VILLAS AT ASPEN TRAILS PRELIMINARY PLAN

LOCATED IN SECTION 9,
TOWNSHIP 15S, RANGE 65W, OF THE 6TH P.M.,
EL PASO COUNTY, STATE OF COLORADO

REVISIONS:	DATE
NO. DESCRIPTION	
PROJECT NUMBER:	0219-06
SHEET	3 OF 8

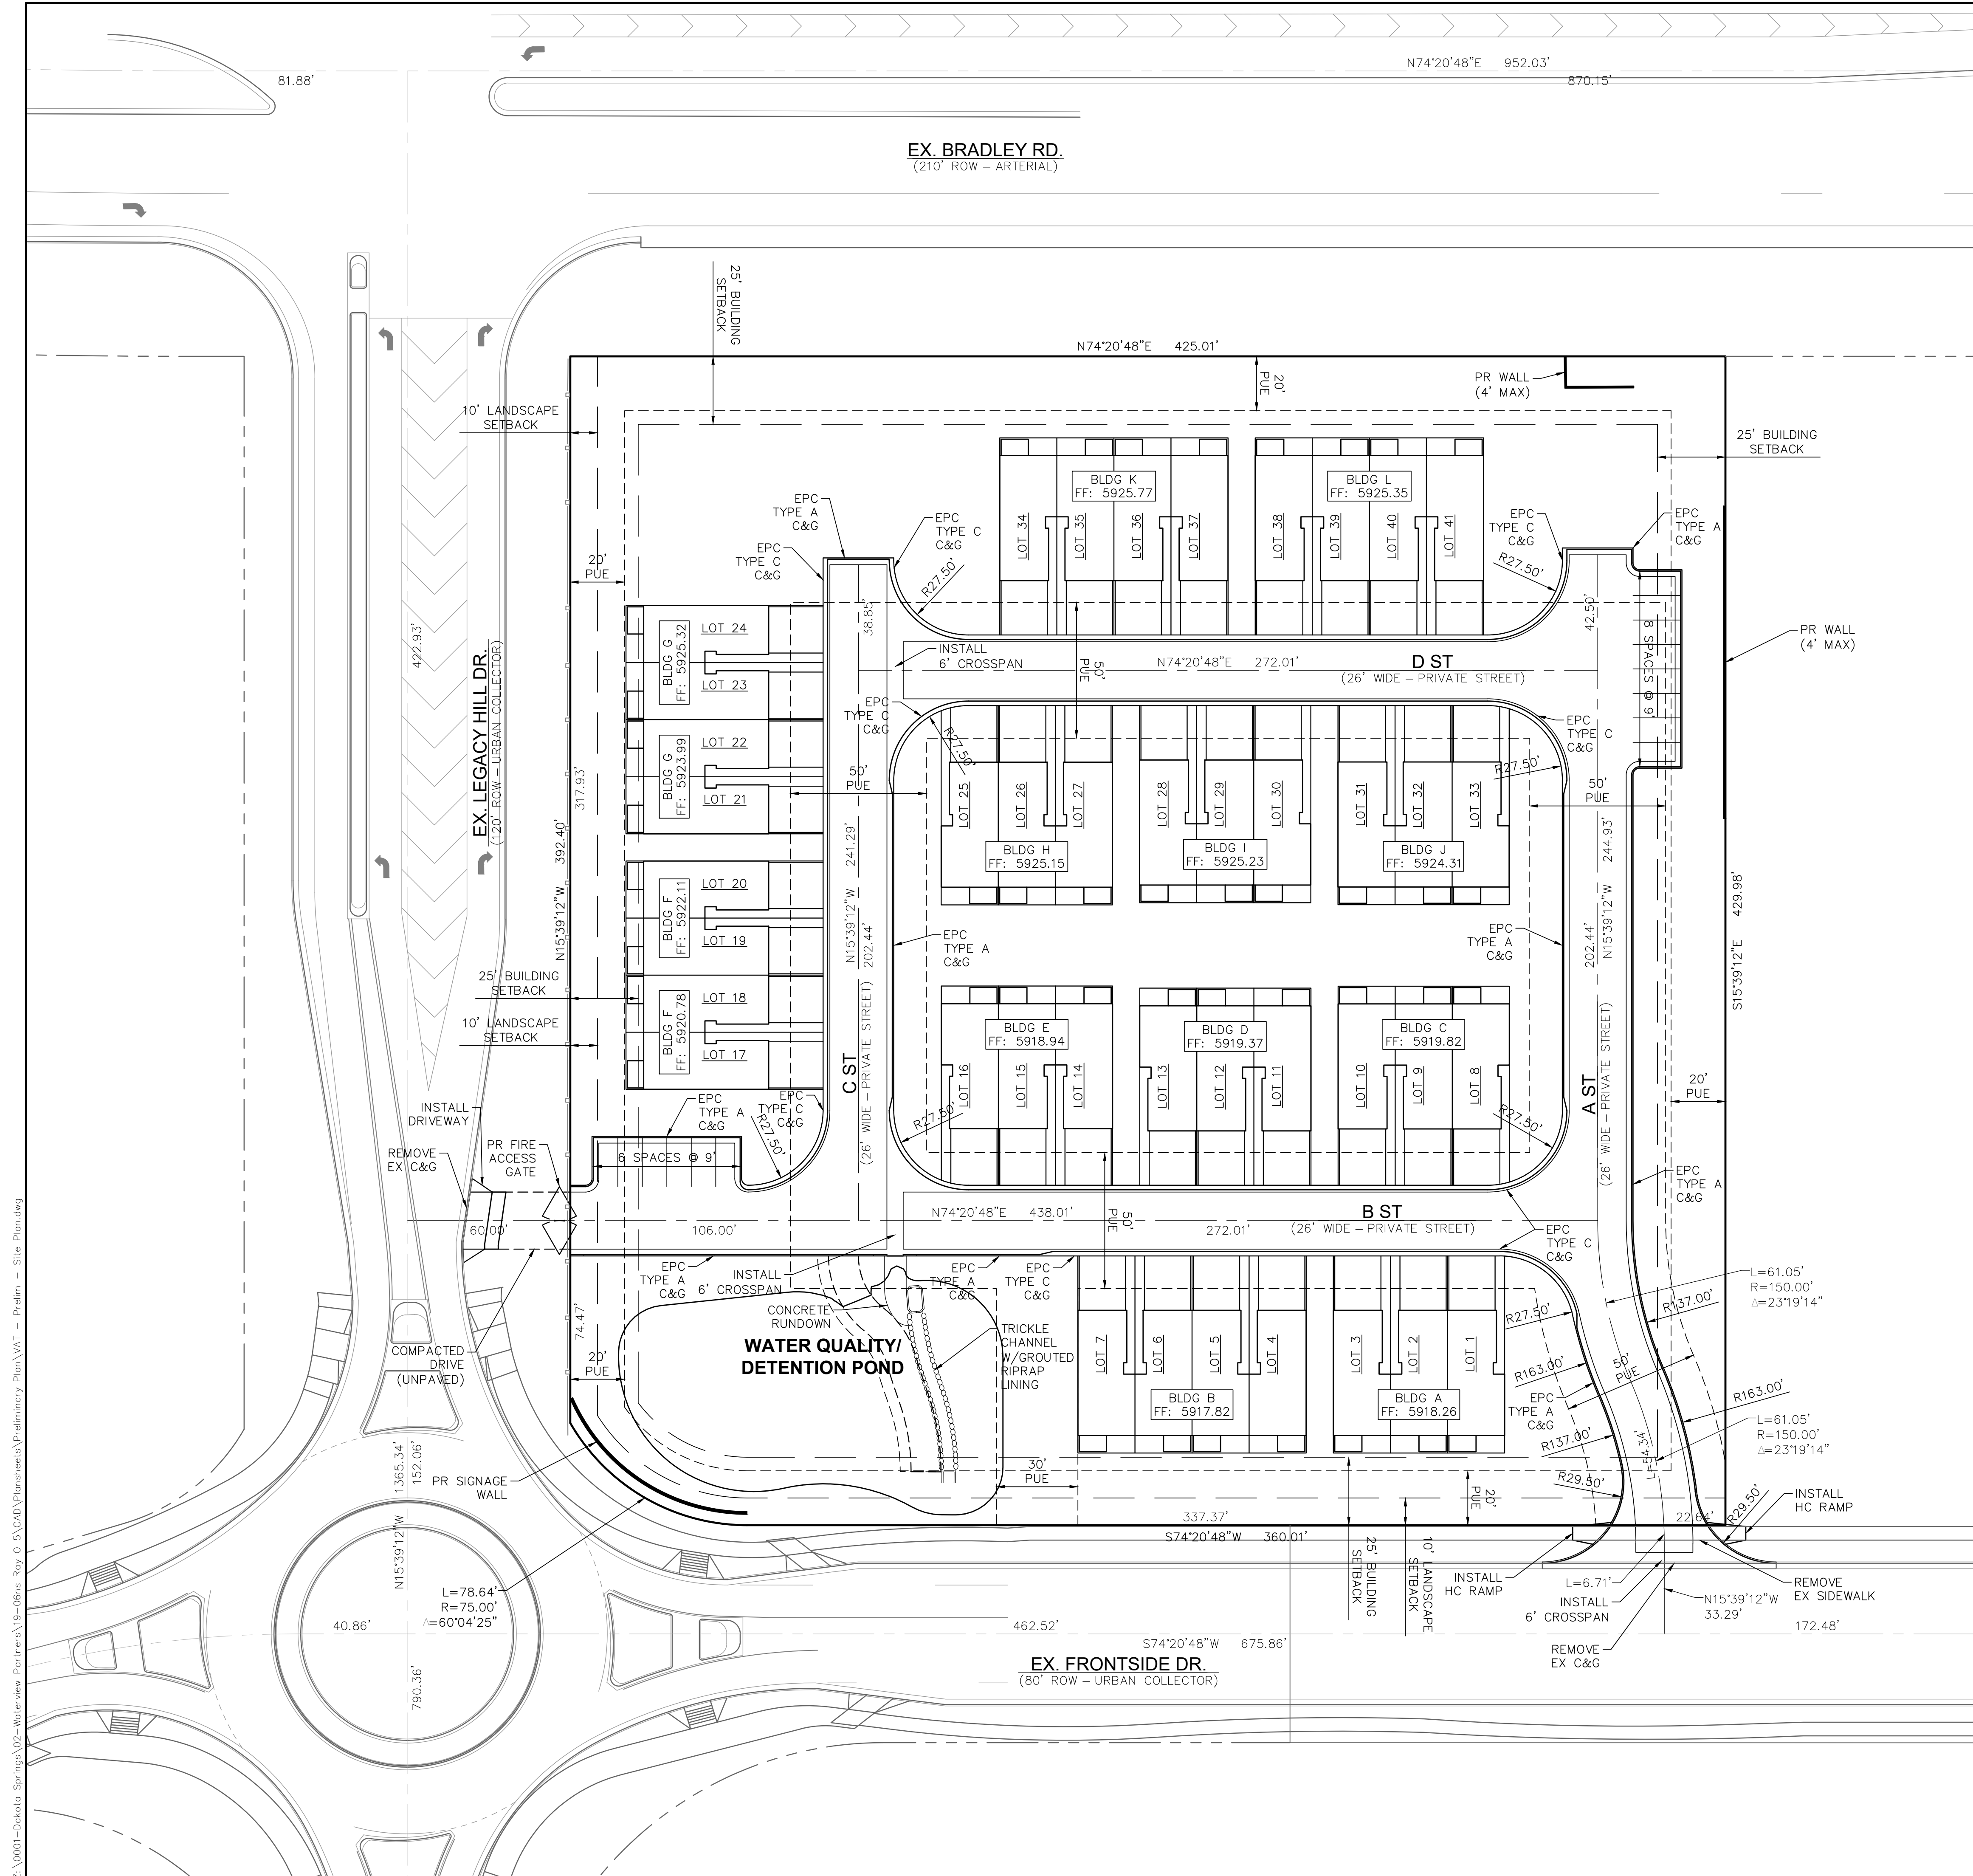
Missing all interior sidewalks and connections. No PED route. Deviation review pending but there appears to be room for a sidewalk at entrance and east side along main entrance. There is no lighting plan submitted.

Update street names

Add EPC Private Street sign design detail

provide gate design detail

provide design detail

call and label all sidewalks as existing or proposed and label width.
